East Anglia ONE North and East Anglia TWO Offshore Windfarms

Applicants' Comments on Tessa Wojtczak's 11 Submissions

Applicant: East Anglia TWO and East Anglia ONE North Limited
Document Reference: ExA.AS-28.D12.V1
SPR Reference: EA1N_EA2-DWF-ENV-REP-IBR-001127

Date: 28th June 2021
Revision: Version 1
Author: Royal HaskoningDHV

### Bat Roost and Commuting/Foraging Habitat Results

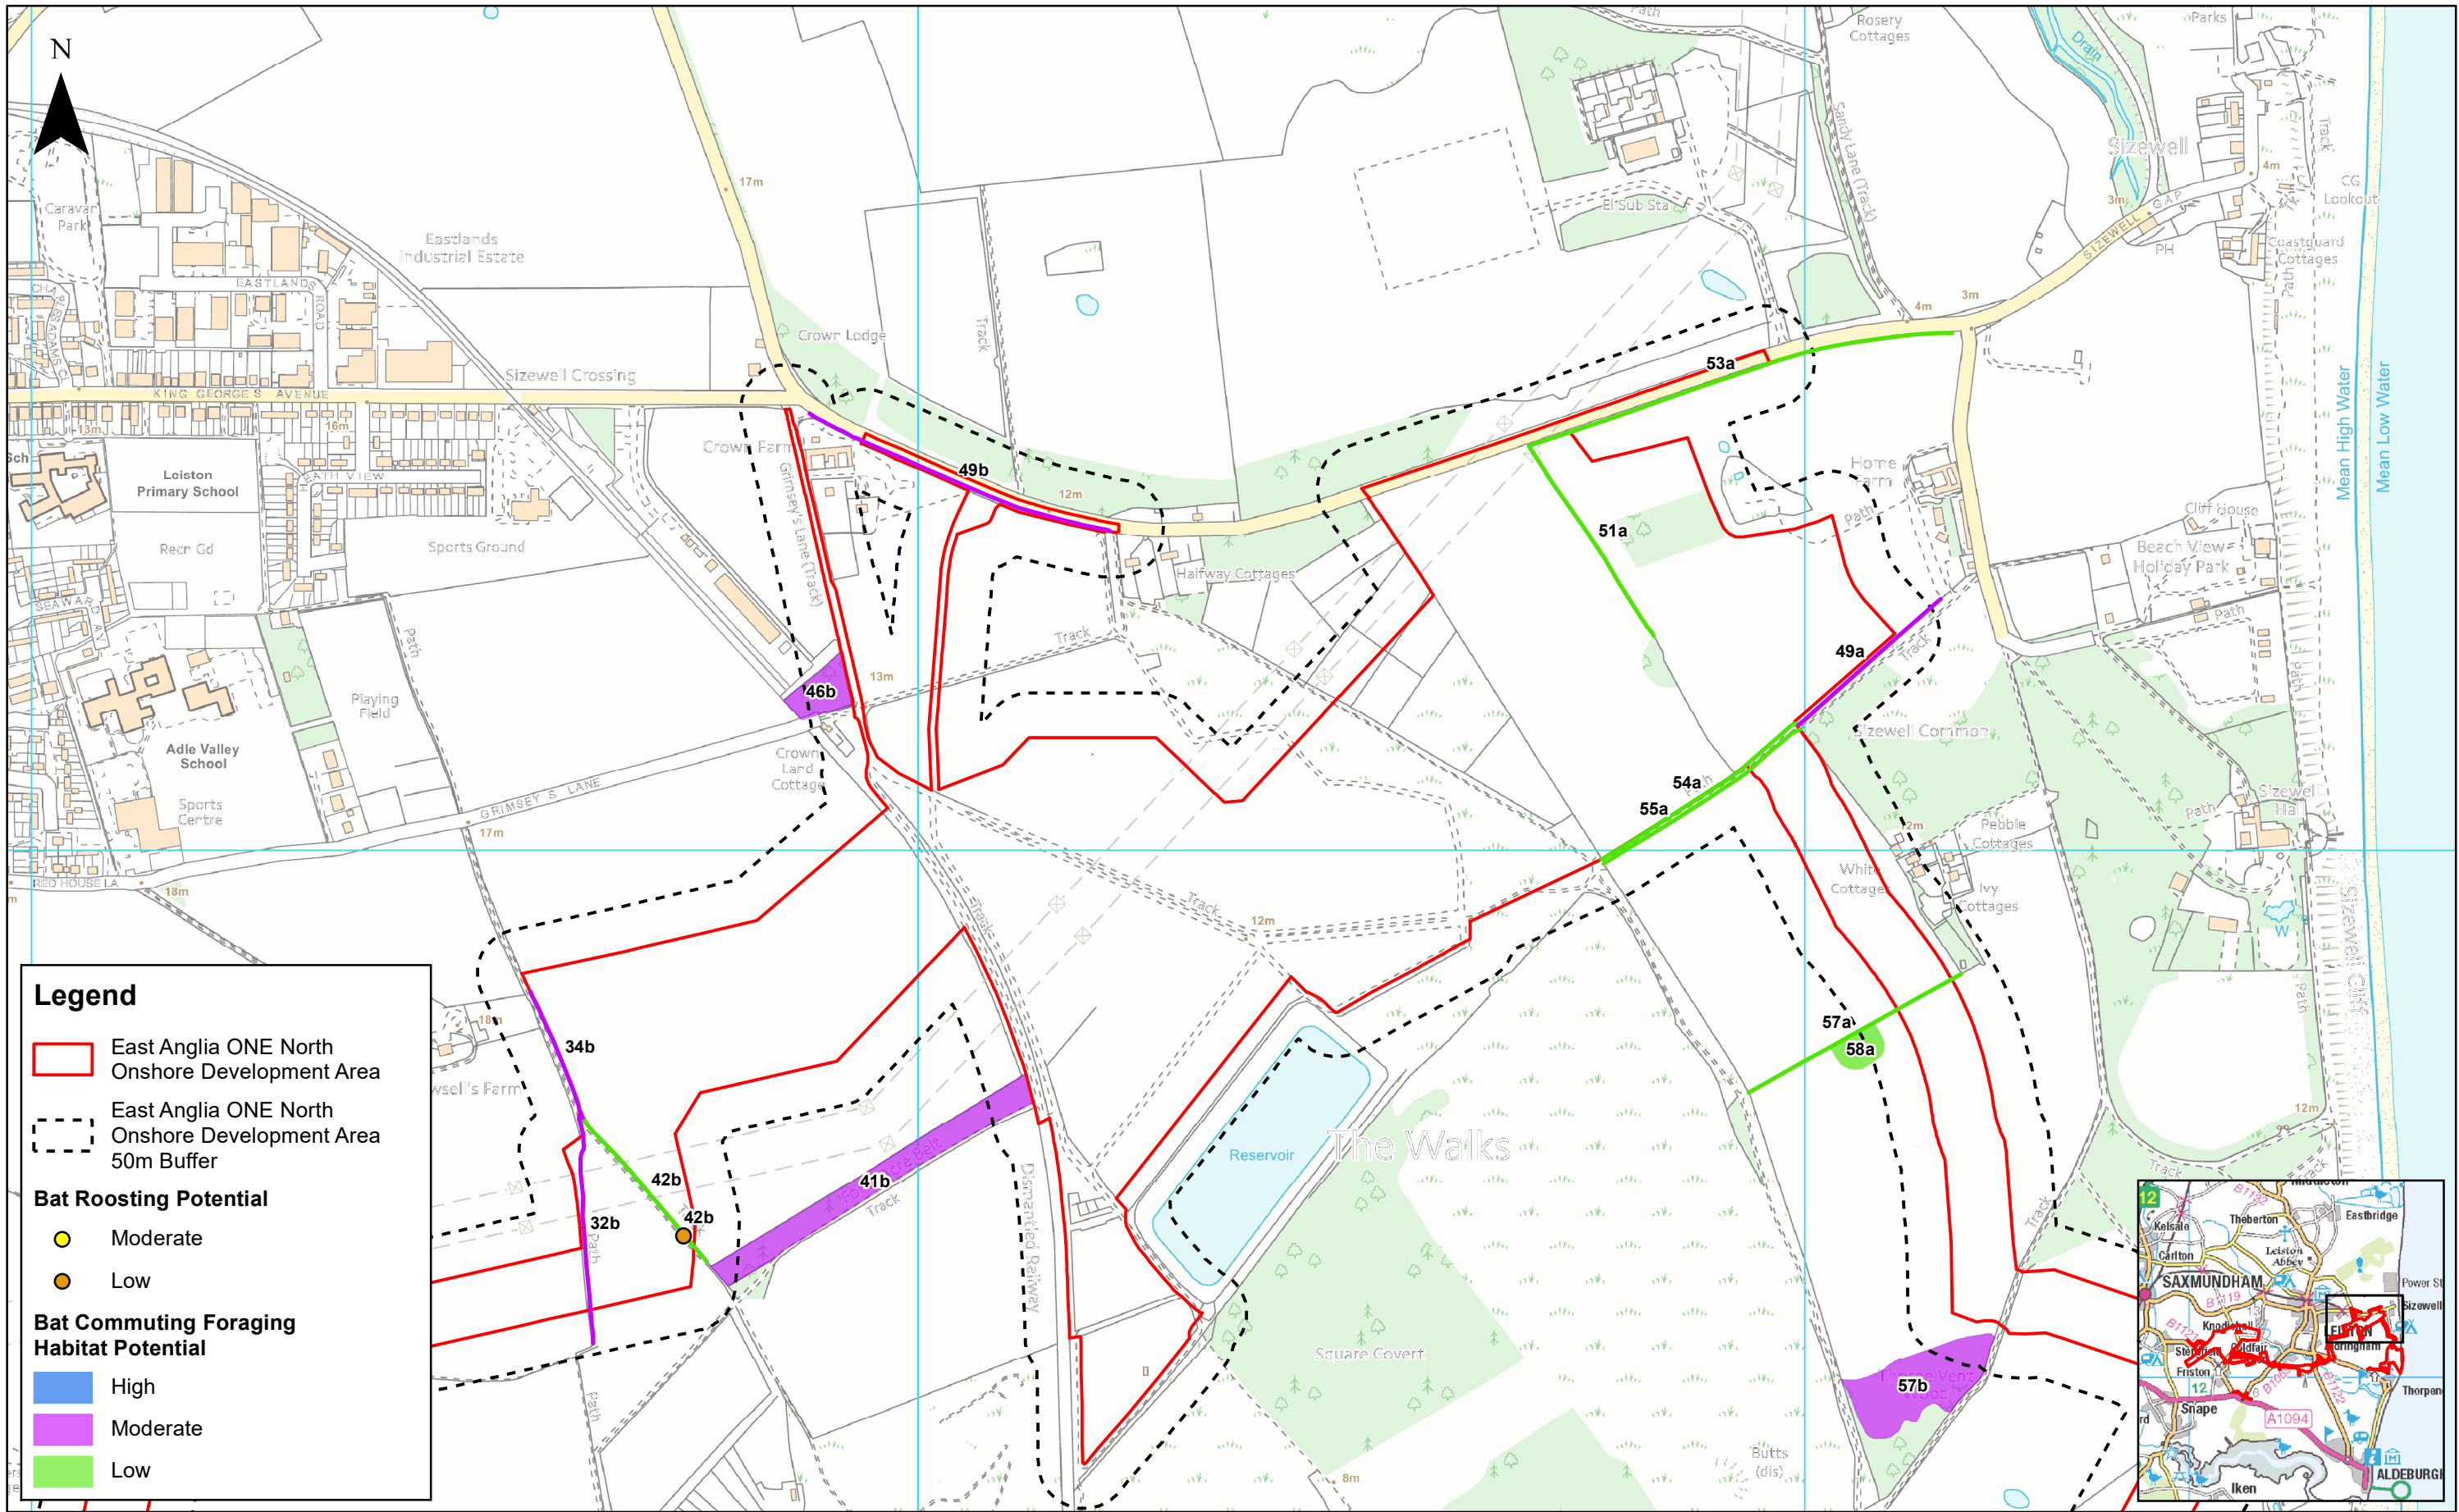
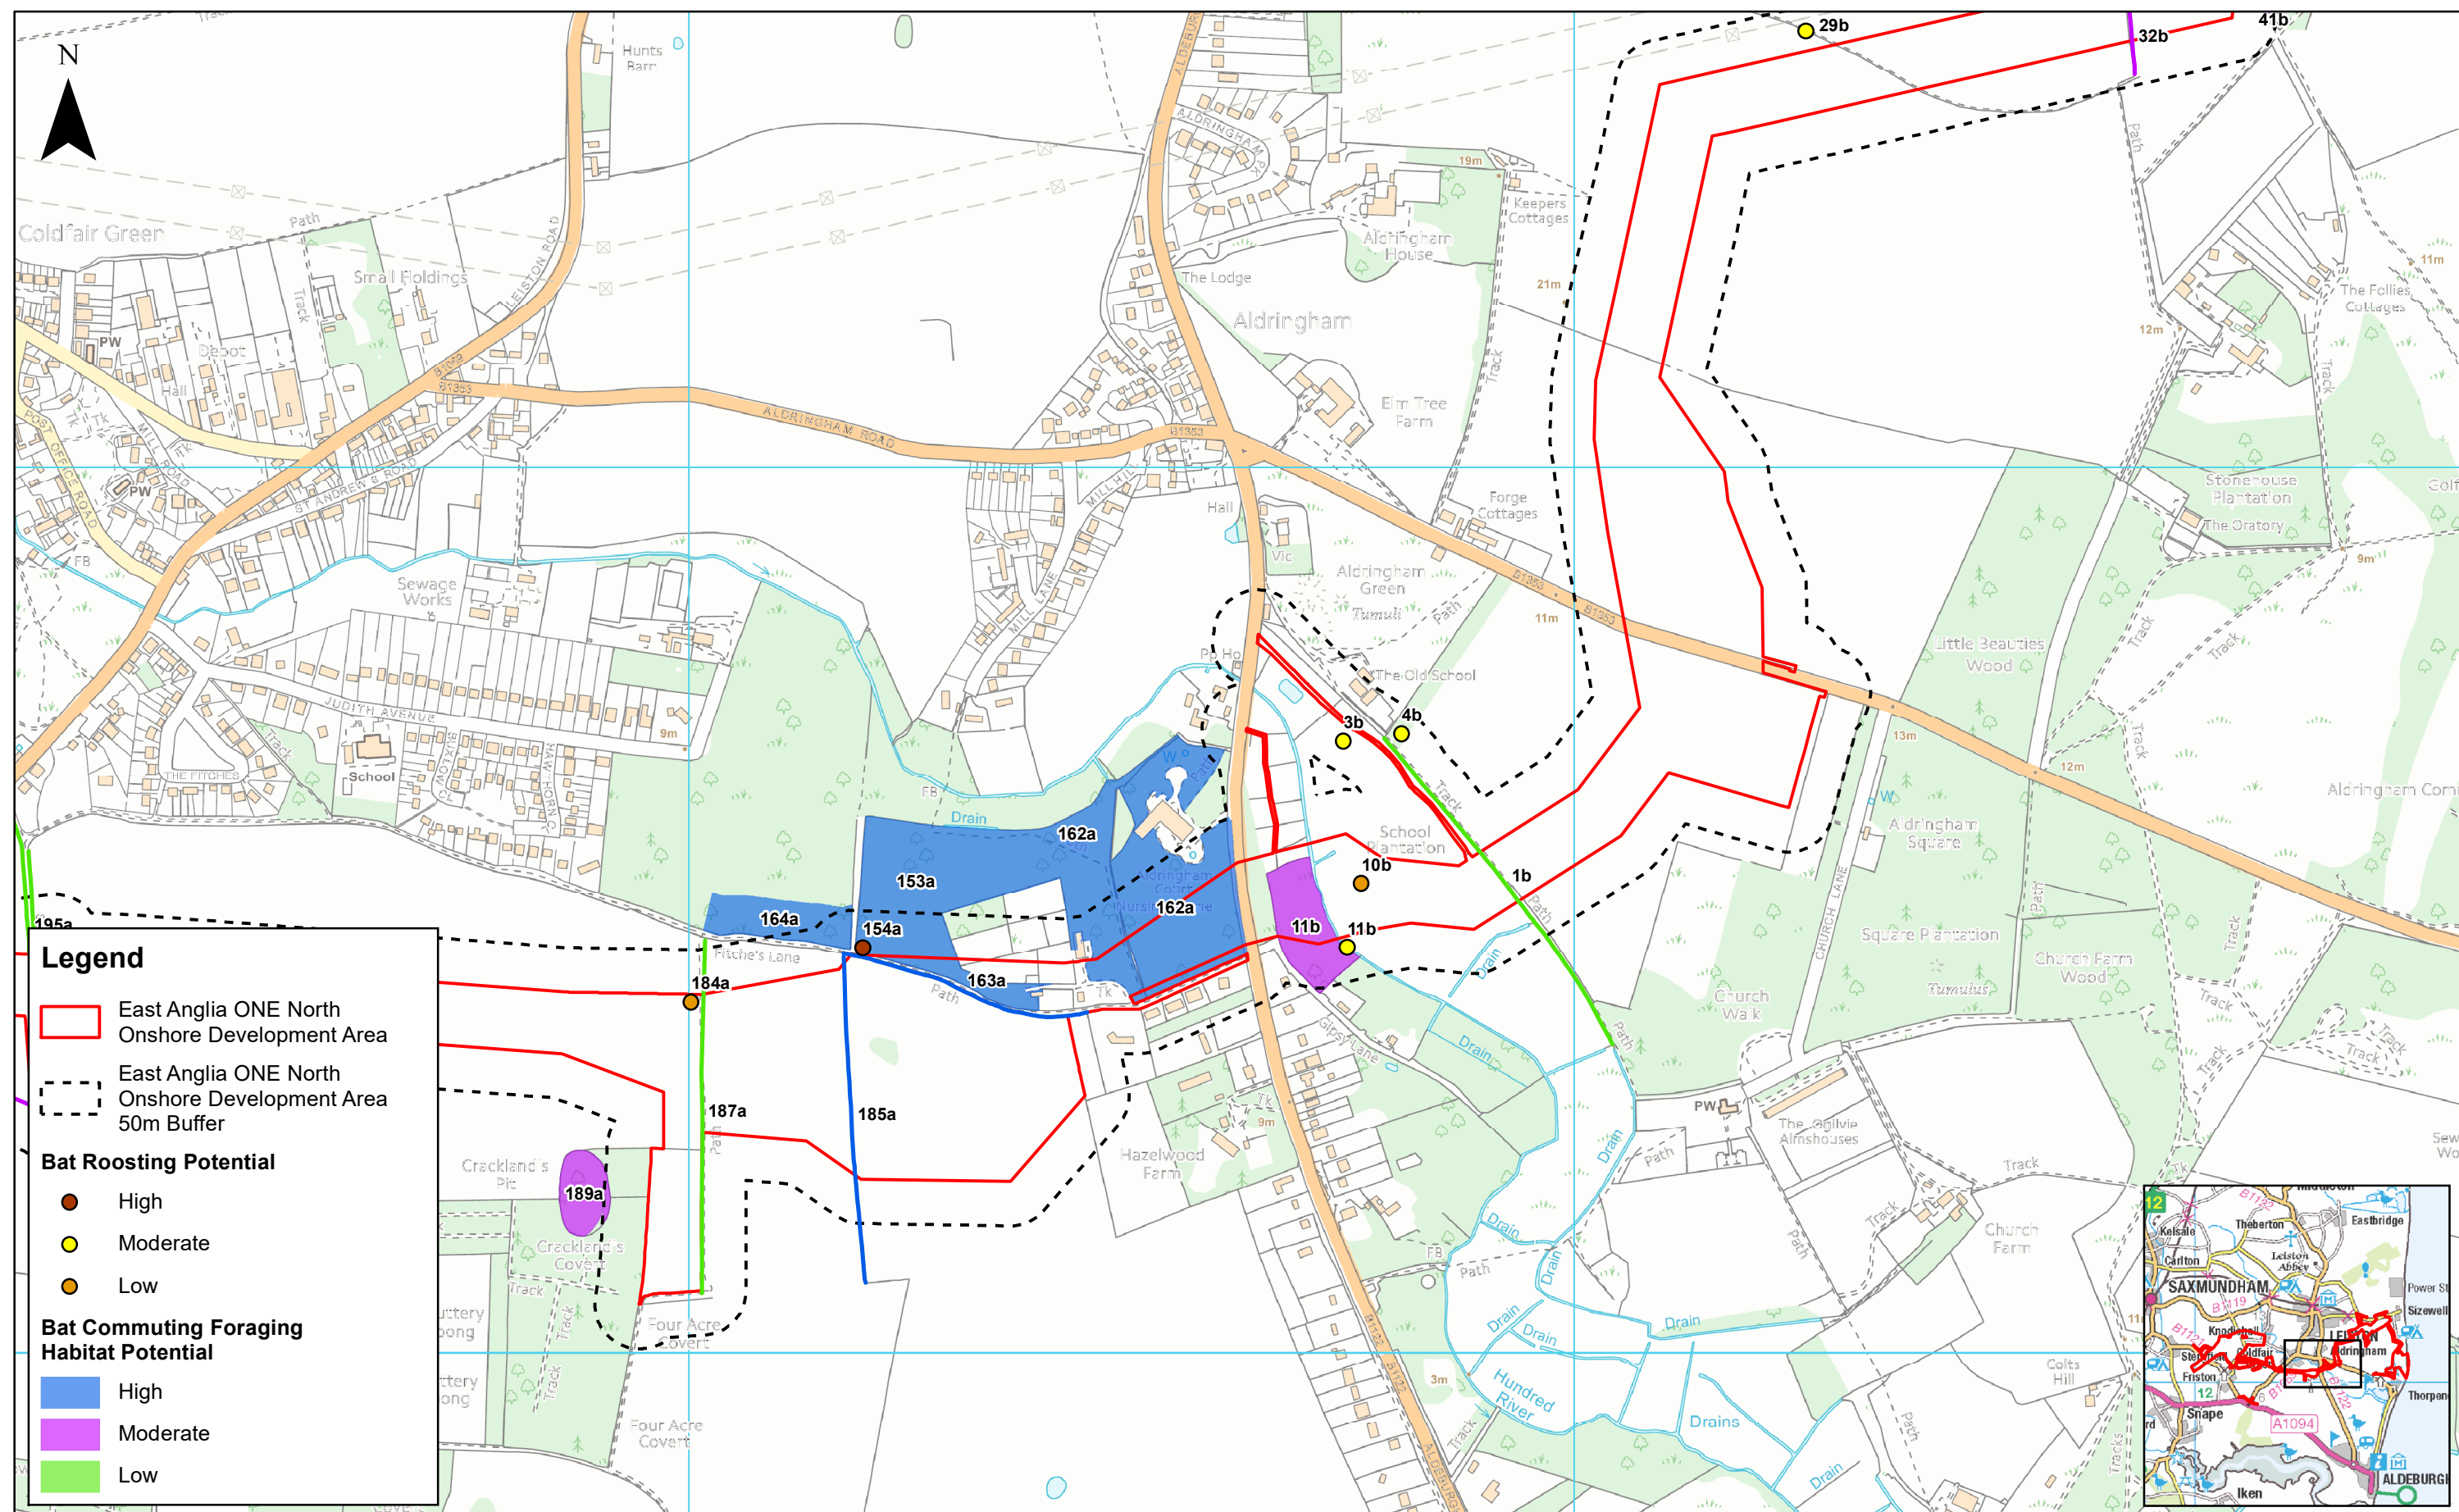
9	<p>Impact 9 , Bats states that no confirmed bat roost sites have been recorded within the Onshore development area.</p> <p>This in itself is remarkable given the extent of that area. However, the Applicants translates that lack of recording of confirmed bat roost as a conclusion as “an absence of this species at this location.”</p>	<p>Ms Wojtczak misrepresents the information within Change Request: Amendment to Order Limits at Work No. 9 (Plot 13) (AS-104). Where practicable, development of the Order limits sought to avoid environmental sensitivities (e.g. potential bat roosts). AS-104 notes that bat activity was observed during surveys across the onshore development area, and that foraging / commuting bats were detected at survey locations near to the coast.</p> <p>The area of land brought into the Order limits by the realignment has no bat roost potential (being the centre of an intensively farmed arable field). There is a single hedgerow (potential bat commuting feature) present within this stretch of</p>

ID	Tessa Wojtczak's Comment	Applicants' Comments
	<p>At present there is, as there is every year, constant and prolific activity of pipistrelle bats in our garden, along the track and across all the fields adjacent. It is a false conclusion; and yet it stands</p>	<p>the Order limits; the realignment will require the removal of a shorter section of this hedgerow than previous. Therefore, the assessment conclusions regarding bats within Chapter 22 Onshore Ecology (APP-070) remain valid.</p>
10	<p>Impact 10. Great Crested newts (which we have observed, apparently emerging from Plot 13 and approaching the pond at Wardens). The Applicants state that “ aquatic habitats are not present at this location “.</p> <p>The Panel has seen the wildlife aquatic pond directly over the fence from Plot 13 at Wardens; not within the Order Limits, but surely of significance in this respect as habitat for Great Crested Newts. Again, the statement does not reflect the reality, and yet it stands within the ES.</p>	<p>See Applicants' response at ID8.</p>
